**New Gledswood Hills Public School,
Lot 3, The Hermitage Way, Gledswood Hills (SSD 8378)
Notice of Exhibition**

TfNSW has reviewed the exhibited Environmental Impact Statement (EIS) supporting the proposed development and provide the following comments.

Figure 3 – Location of Bus Bay and Drop Off Zone

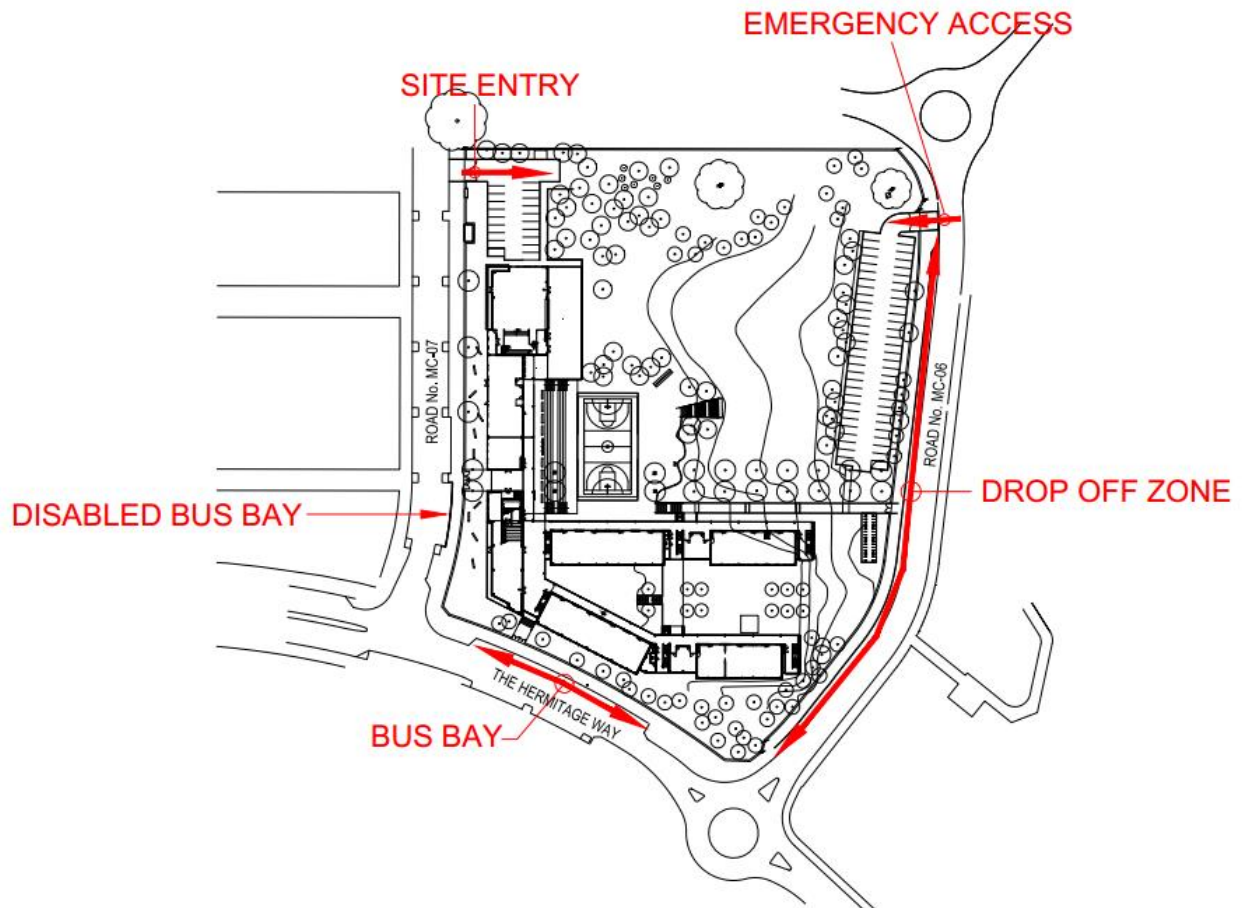
- The Turner Road Precinct Development Control Plan (Aug, 2009) indicates a future public bus route along The Hermitage Way, along the site's frontage. Any public bus service will operate bi-directionally and likely to also be used by school students. As such, a bus stop may be required on The Hermitage Way for westbound/ northbound services within proximity of the school access point.
- The TfNSW Growth Services Program routinely monitors regular bus routes and additional services can be provided, subject to demand and funding. The Applicant should provide 12 months advanced notification to TfNSW and the local bus operator of their intention to commence school operations.
- Prior to commencement of school operations, the proponent should provide additional data and the proposed student catchment area to determine the likely demands on the transport network (all modes).

- It is likely that the majority of pick-up and drop-off will occur on both sides of Road MC06 and MC07. This will require pedestrians (including children) to cross the road to/from their vehicles. As such, appropriate pedestrian crossing facilities should be provided on Road MC06 and MC07 from the respective school access points to provide safer crossing points. The precise details of the facilities should be provided
